Submission Form

Epping to Thornleigh Third Track Proposal. Application number SSI 5132.

Name(s): UNA MASON

Figure S.6 Cross-section and elevation - New Cheltenham Station concourse building (see also S.5 for artist's impression)

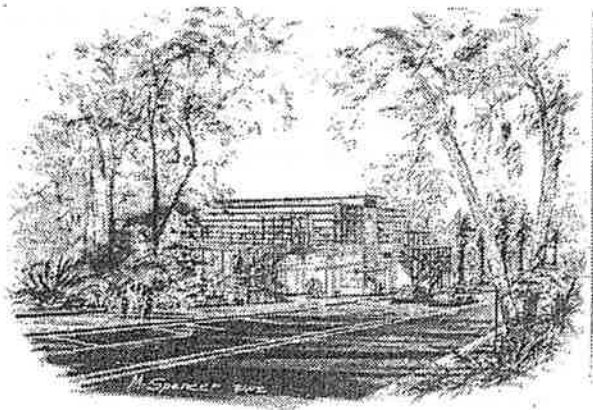
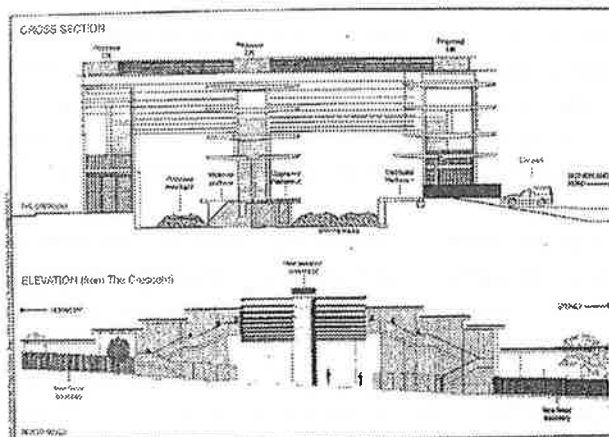
- The proposed redevelopment of Cheltenham Station shows no regard for the HCA. The visual impact of the proposed 13m high glass and steel concourse is totally unacceptable in this HCA.
